January 16, 2007

RE: Residence Inn by Marriott  
Hancock Street and Fore Street  
City of Portland, ME

This letter is in response to your email dated December 23, 2007. Please see below your questions with the responses. I have also addressed the items that Captain Cass had and they are address below under your comments.

**A1.6**  
DRAWING NO.

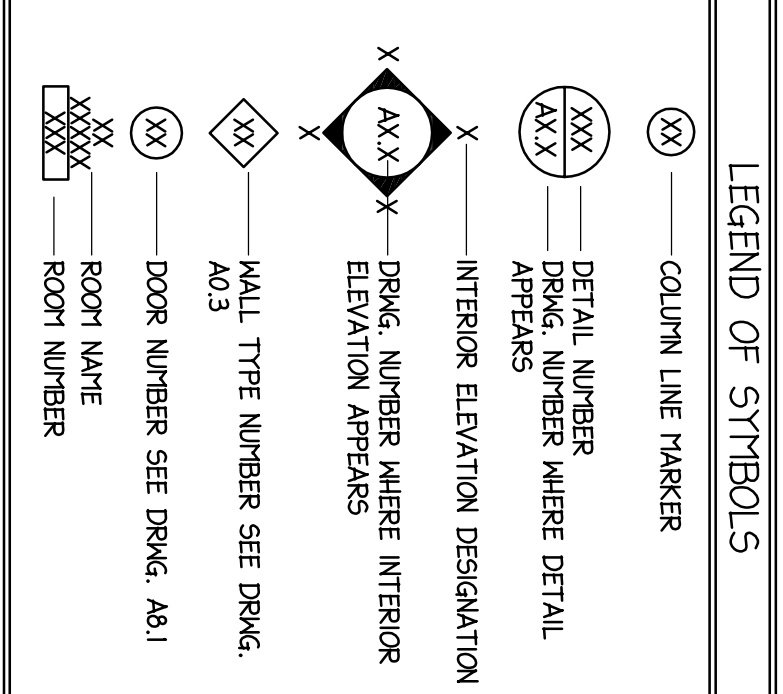
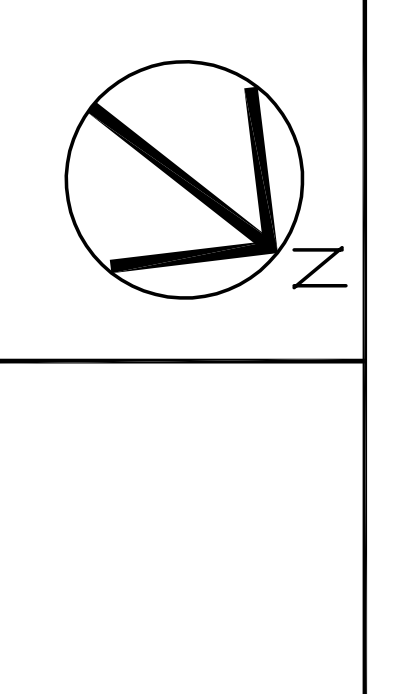
*He asked to relocate the fire department connections from the side of the building to the front along the sidewalk.*

**This modification has been incorporated. Please see attached sheets A1.0 and A1.6.**
